AQUIND INTERCONNECTOR

Environmental Statement – Volume 3 – Appendix 6.1 Physical Processes Consultation Responses

Document Ref: 6.3.6.1

DATE: 14 NOVEMBER 2019

TITLE: **FIGURE 1.1 PROPOSED DREDGE DISPOSAL AREA MAP UK DRAWING 1 OF 2**

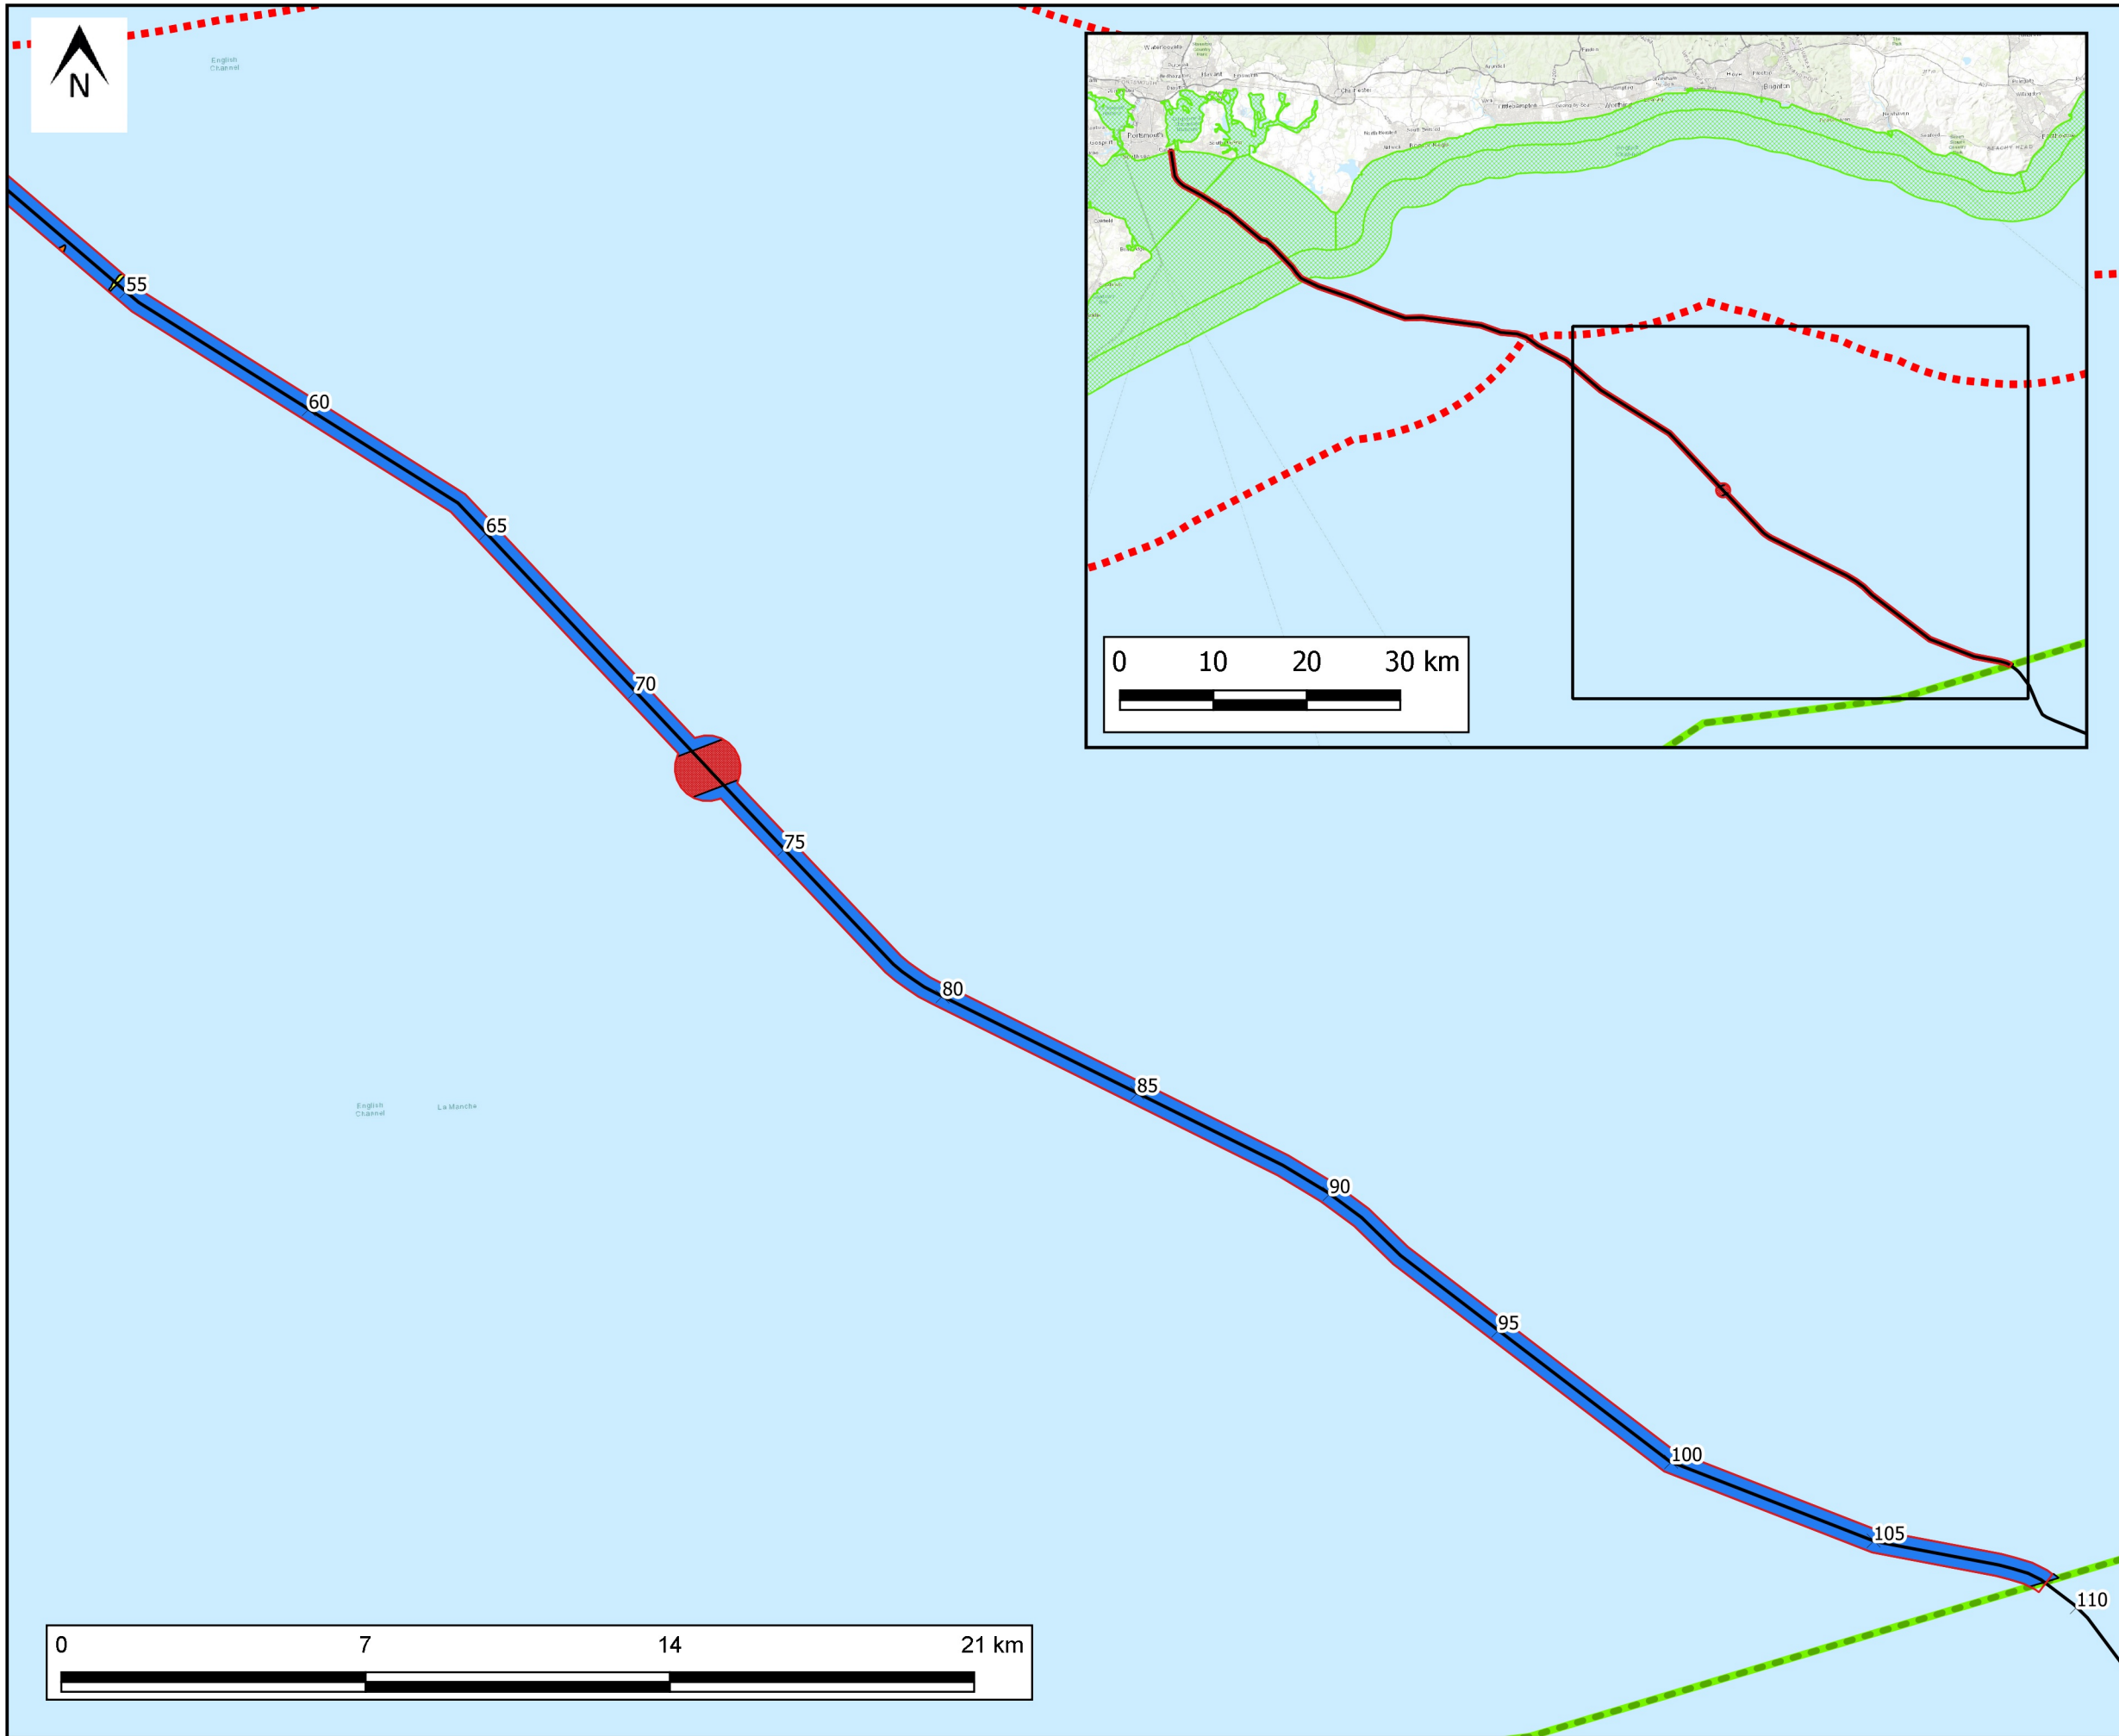
Natural England	Table 6.17 (page 6-100) – Worst Case Design Parameters: Natural England requests an understanding of how the figures have been derived for the dredged material. In addition to this, the area of seabed that will be impacted by dredging and	<p>The worst-case design parameters (now detailed in Table 6.15) includes the total area of dredging footprint. How dredge volumes were determined is provided in paragraph 4.2.2.4 of Appendix 6.2.</p> <p>Appendix 6.5 (Disposal Site Characterisation Report) of the ES Volume 3 (document reference</p>

Consultee	Summary of Comment Received	How this has been addressed by the Applicant
	disposal should be defined in terms of seabed footprint and not just the volume.	6.3.6.5) presents further information relating to characterisation of the proposed disposal site. Within this chapter, the area of disturbance resulting from the construction activities such as dredging has been quantified. However, seabed disturbance has not been considered as an impact itself but, has been considered with regards to its potential resultant impacts e.g. increased SSC.
Natural England	Table 6.17 (page 6-100) – Worst Case Design Parameters: Natural England recommends that for clarity, it would be of benefit to list the Worst-Case Scenario (WCS) by impact rather than the activity. For example, several potential impacts are listed as causing increases to nearbed Suspended Sediment Concentration (SSC) but it remains unclear as to which is the worst case for nearbed SSC. Some of the potential impacts may result in higher concentrations of SSC over a small area and others a lower SSC concentration over larger areas.	The worst-case scenarios for the Proposed Development for different impacts is provided in Table 6.15) of this chapter and includes identification of which activities are considered the worst case scenario for different receptors.
